**Consultation Response from KC,  
Trees**

**2024/92075 2 A, East Bath Street, Batley, WF17 5NP**

**Demolition of existing dwelling and erection of two detached dwellings**

**Date Responded: 05/06/2025**

**DRG:**  
PROPOSED SITE PLAN

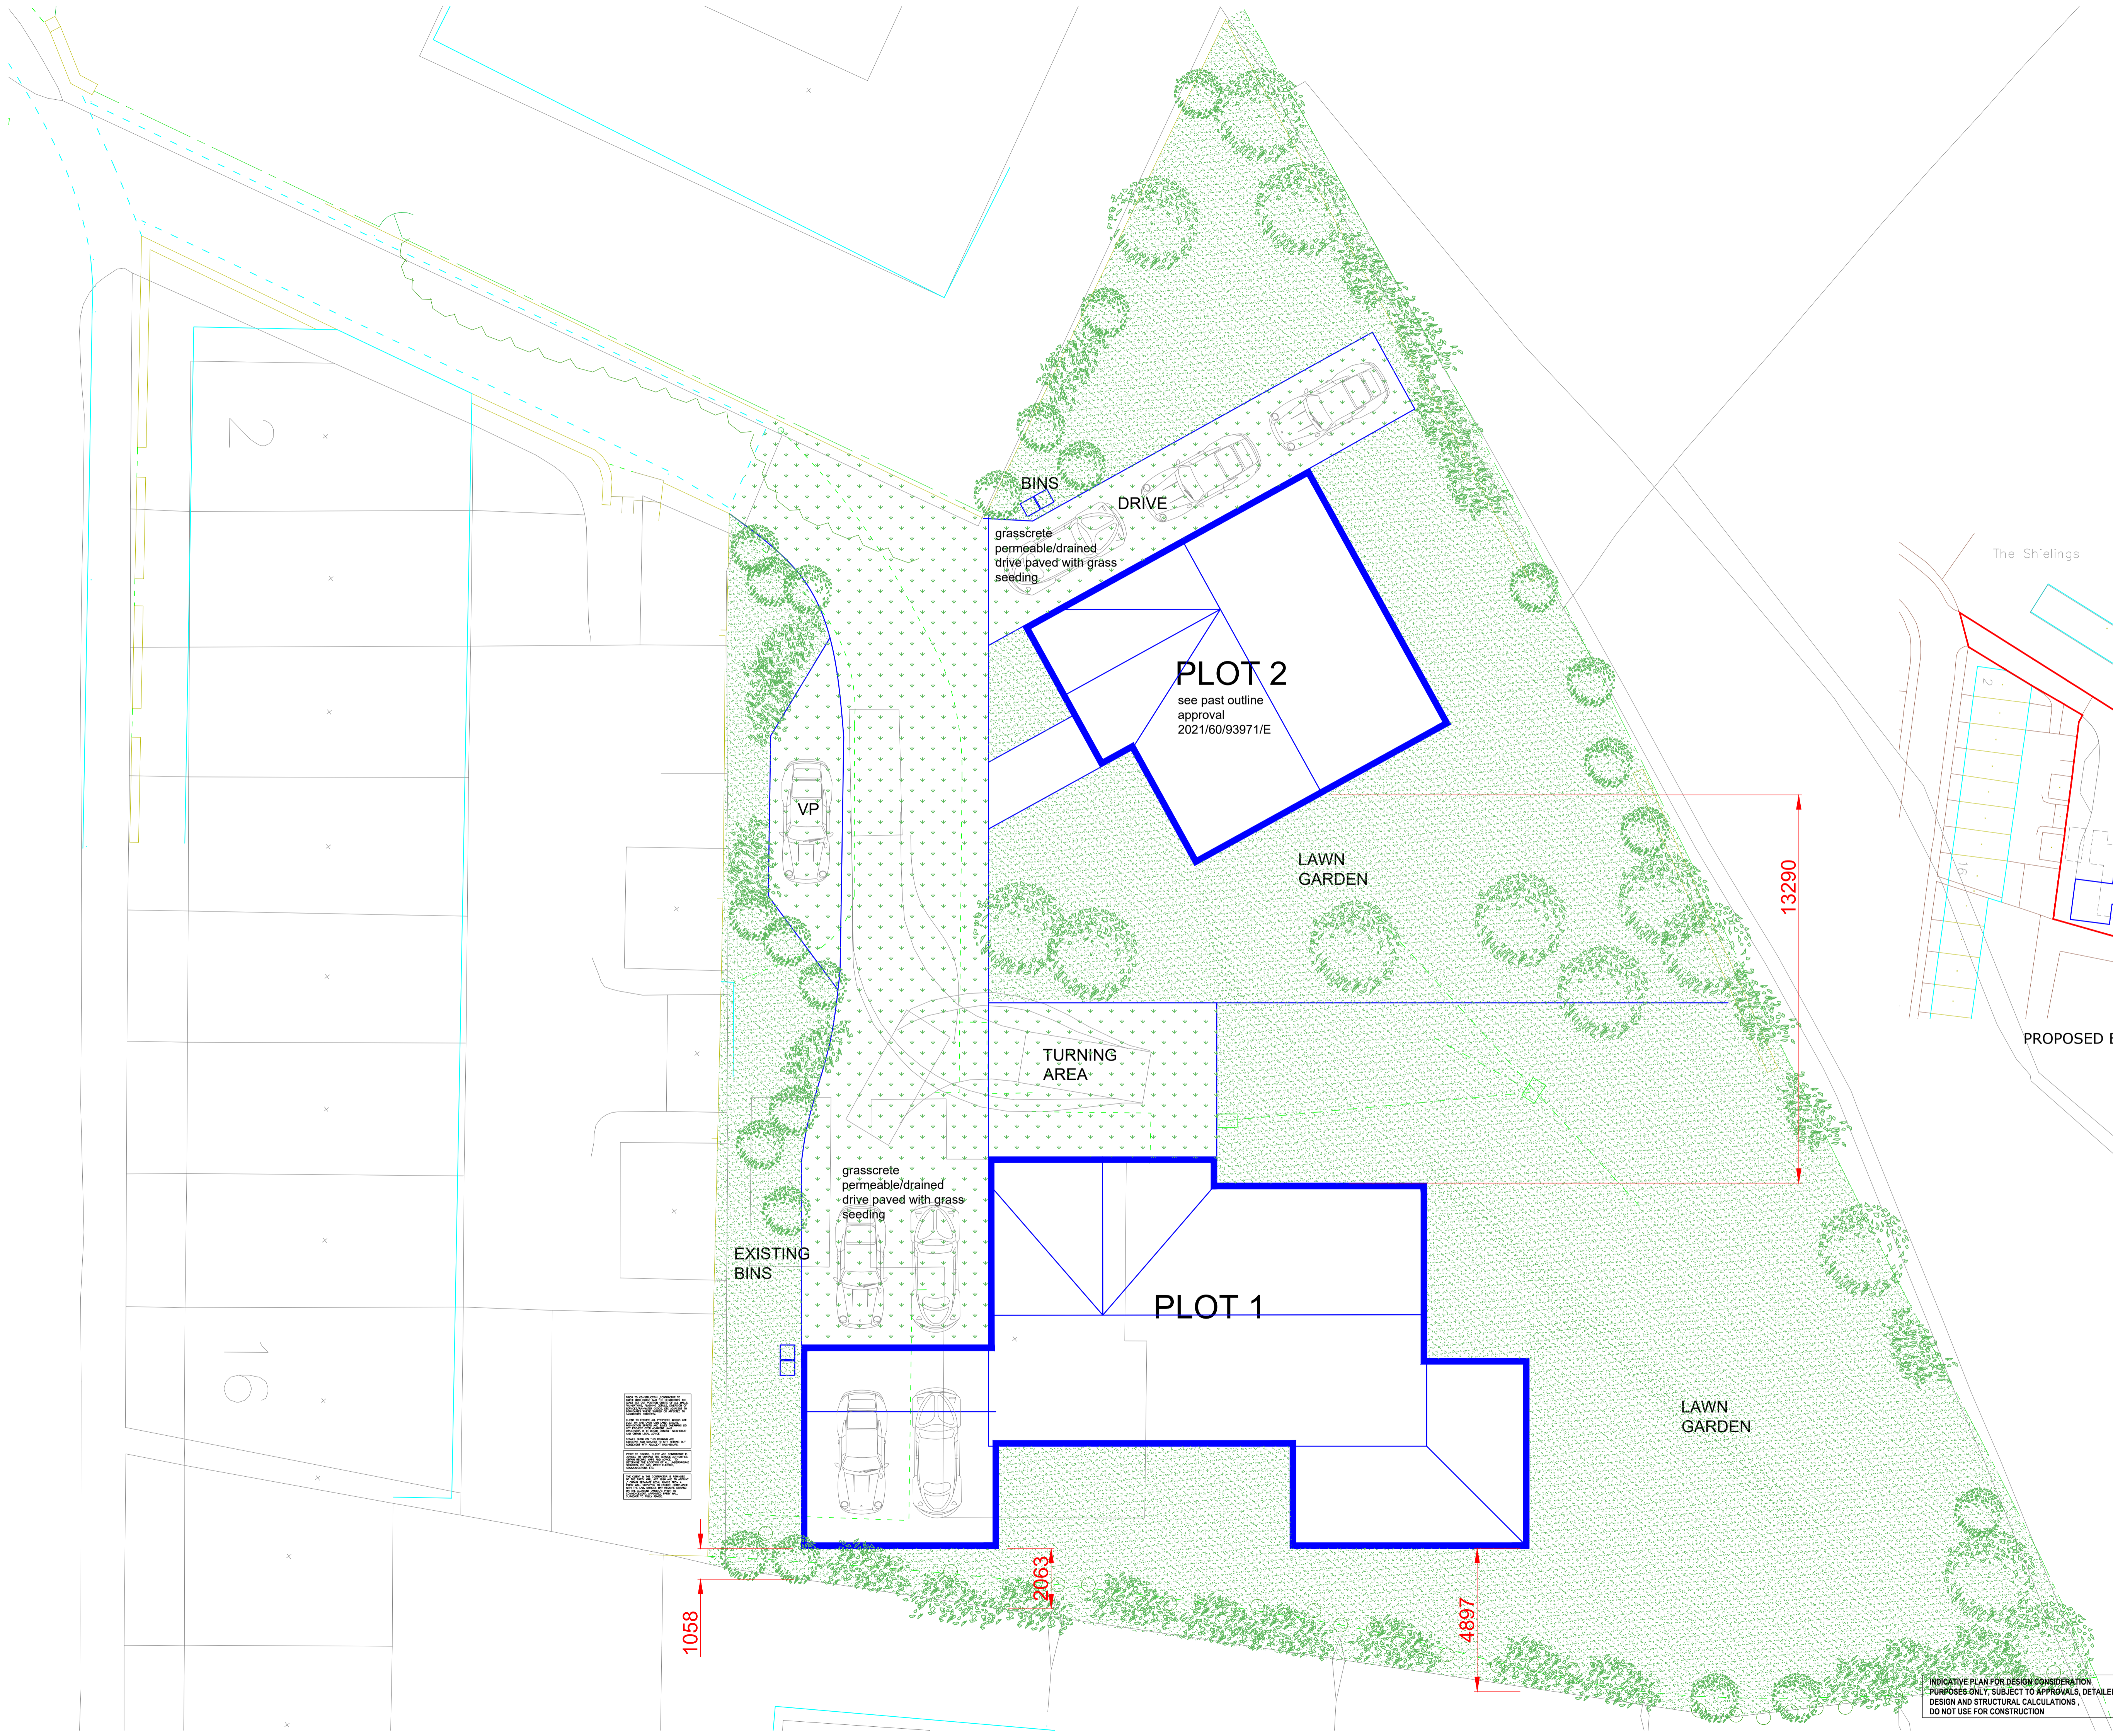
The new layout would require the removal part of H8 to accommodate the construction of Plot 1. This will cause a loss of the screening into the site offered by the existing Leyland Cypress hedge (currently up to 16m tall) but is acceptable from an arboricultural perspective.

The construction of Plot 2 in this amended location would slightly encroach into the RPA of T3. Again, this would be acceptable as the encroachment would be minor and the ground protection stipulated within the AMS would prevent the construction from causing any further damage e.g. compaction to the soil environment within the RPA.

Additionally, the western edge of the canopy of T3 would conflict with the southeast corner of the proposed house, if constructed in this updated location. The AMS should be amended to include the access facilitation pruning required to create working space between plot 2 and the canopy of T3. This pruning work should be carried out prior to the commencement of construction to prevent accidental damage to the tree.

**Subject to the amendment of the AMS, to include the access facilitation pruning to T3 as described above, there are no objections to the proposals from an arboricultural perspective.**
